CONDITION AMMENDMENT - MODIFICATION TO COLD STORAGE FACILITY - SSD 6799 MOD 1

Further to recent correspondence between the NSW Department of Planning, EMKC and Urbis this letter has been prepared to summarise the conditions in addition to those identified by the Urbis Section 96 (2) Application to SSDA6799 prepared by this office and dated 18 May 2017. Amendments to the conditions are show in in **red and bold** below in the Table below

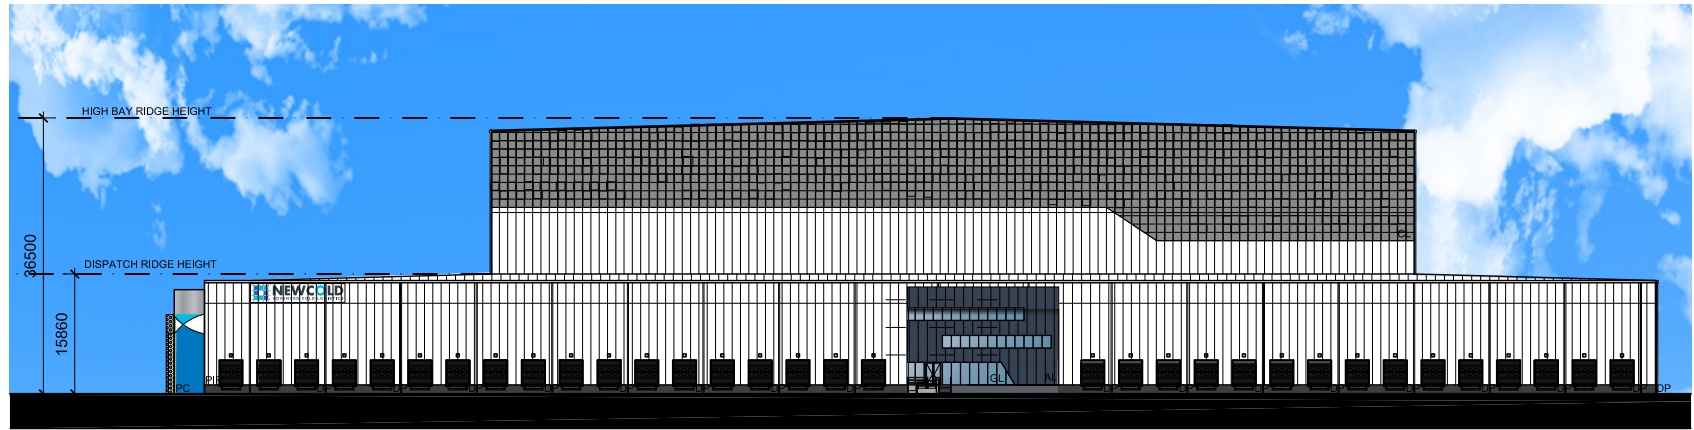
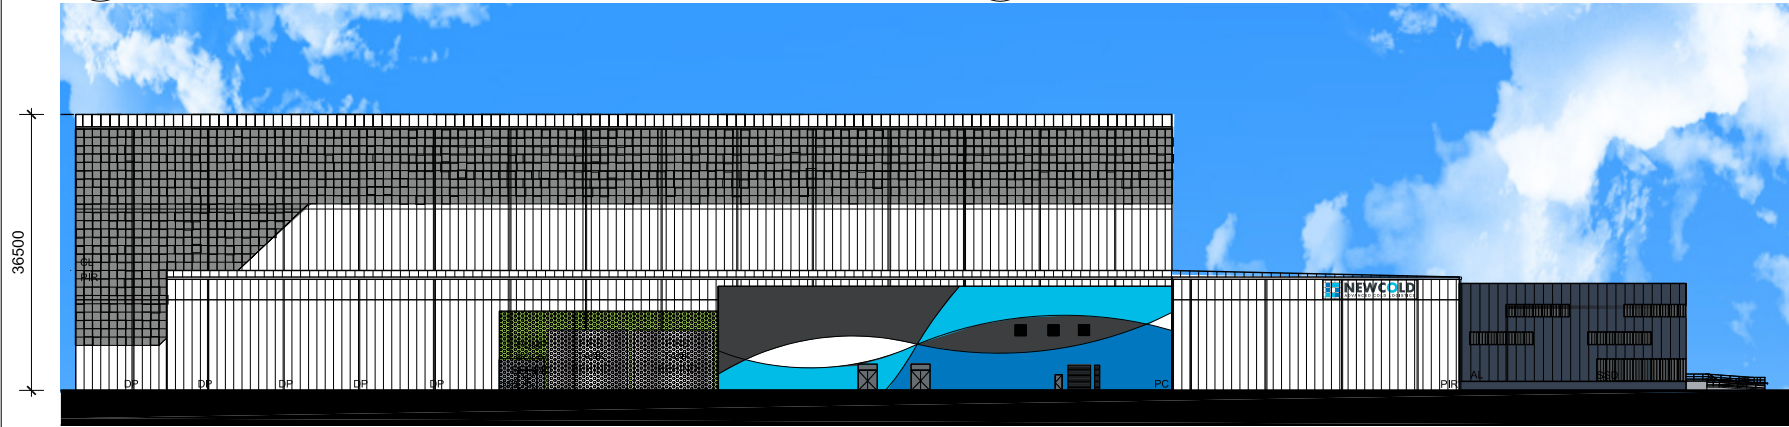
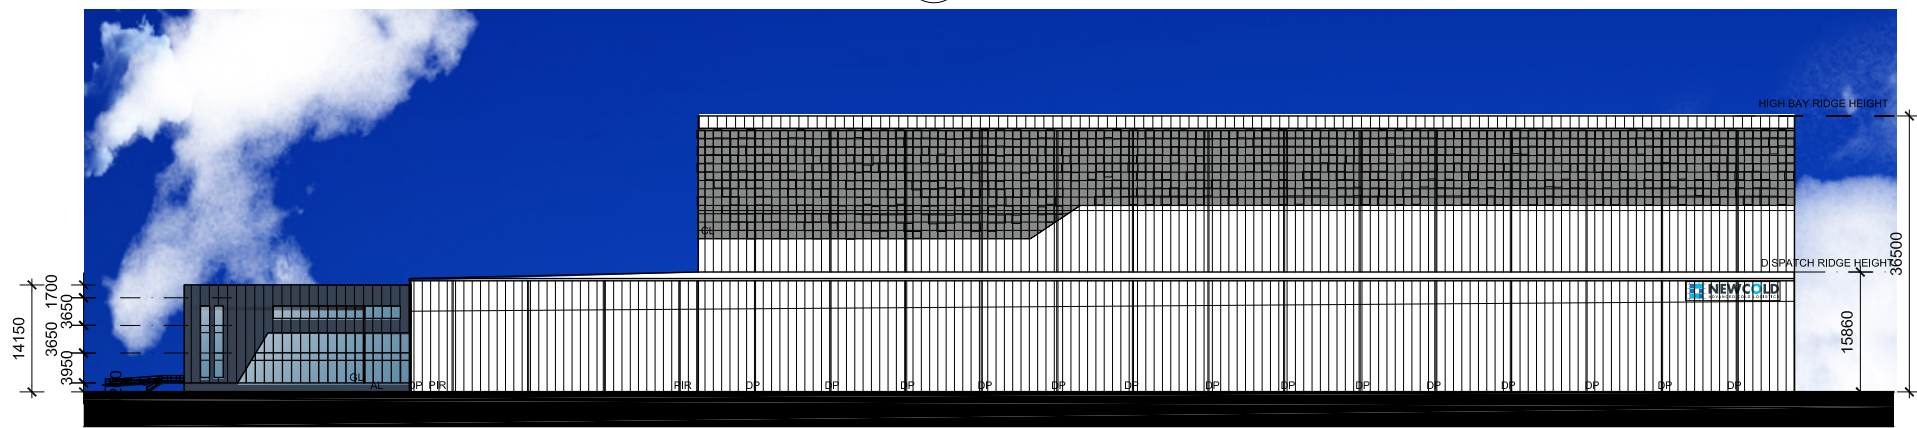
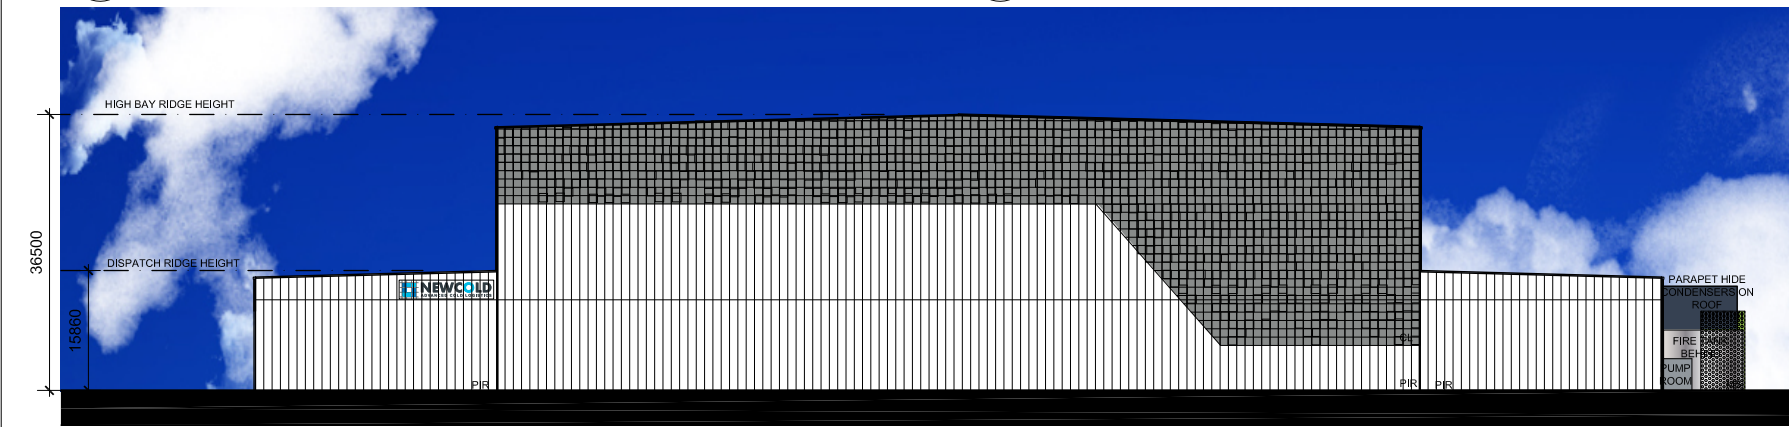
C48 All signage shall be erected in accordance with specifications identified in the following drawings:

- a) ~~2520460-96-0-502 Elevations Overall Development (Revision B) prepared by Beca and dated 20 July 2015 (north elevation 12.5 m x 2 m, south elevation 12.5 m x 2 m and west elevation 16m x 2.5m).~~
- b) **AU0012 MDP FS10 200 Proposed Elevations (Revision B) prepared by EMKC and dated 19 April 2017.**
